RE: **Lot 8 Block 3 Unit 19, S.A.D. 228**
Volcano Cliffs Subdivision
7809 Urraca Rd. NW
Grading and Drainage Plan
Engineers Stamp Date; 4-13-2021 (D10D003U8)
Pad Certification Date; 12/3/2021

Based upon the information provided in your submittal received 12/10/2021, this plan cannot be approved for pad certification until the following comments are addressed.

**DRAINAGE PLAN**

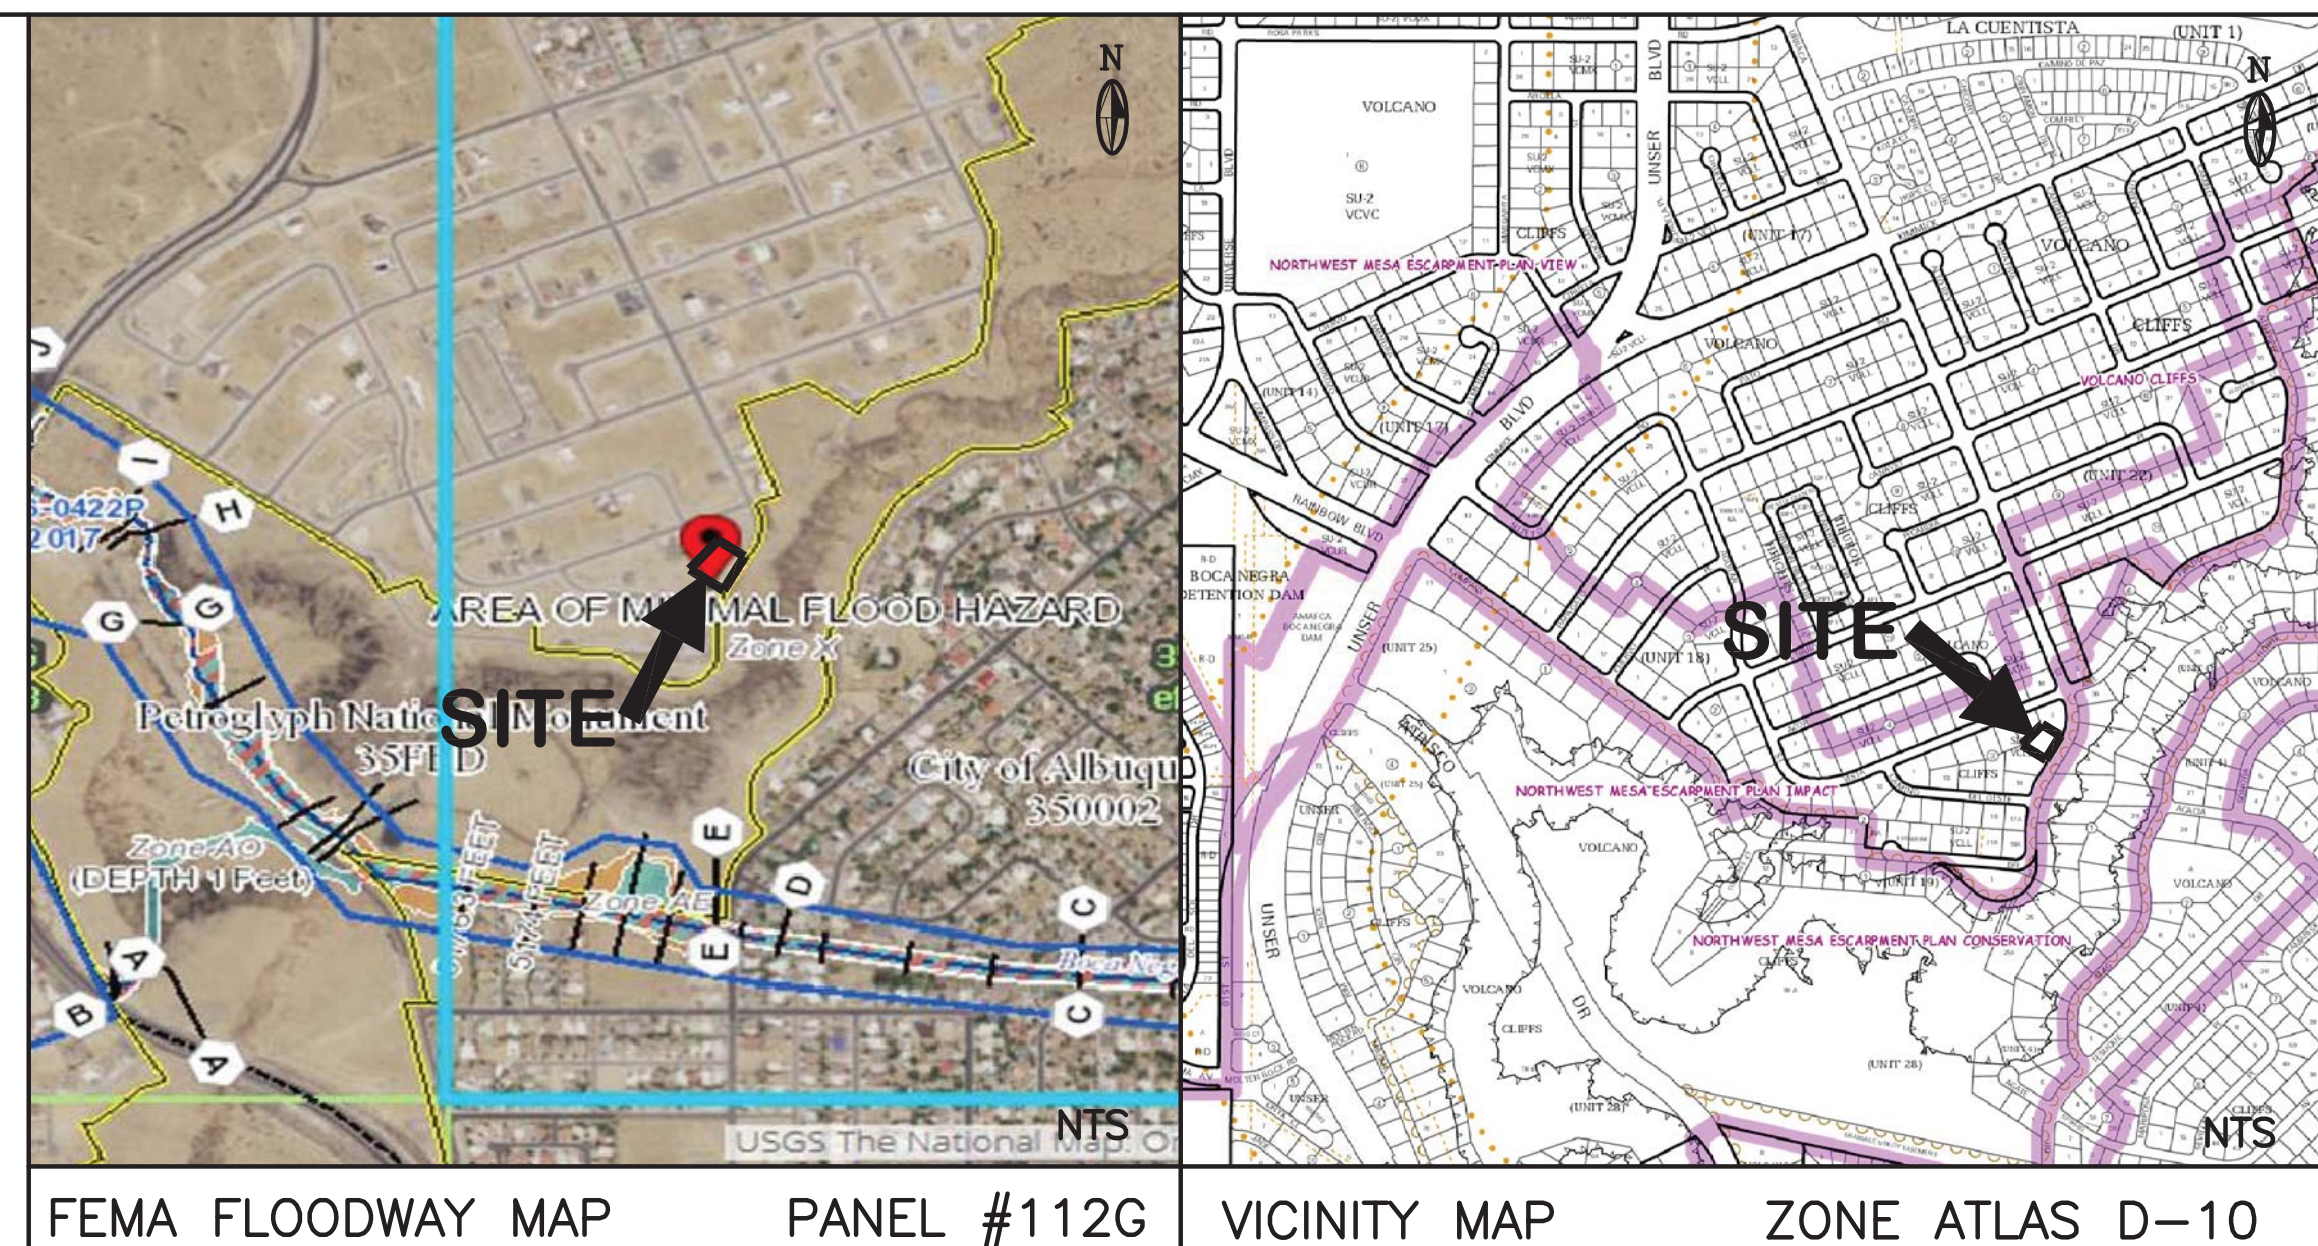
- The home footprint does not match, between engineer & surveyor.
- Provide the FF and FP on surveyor plot.
- Make sure the FF & FP are at the average level for the site.
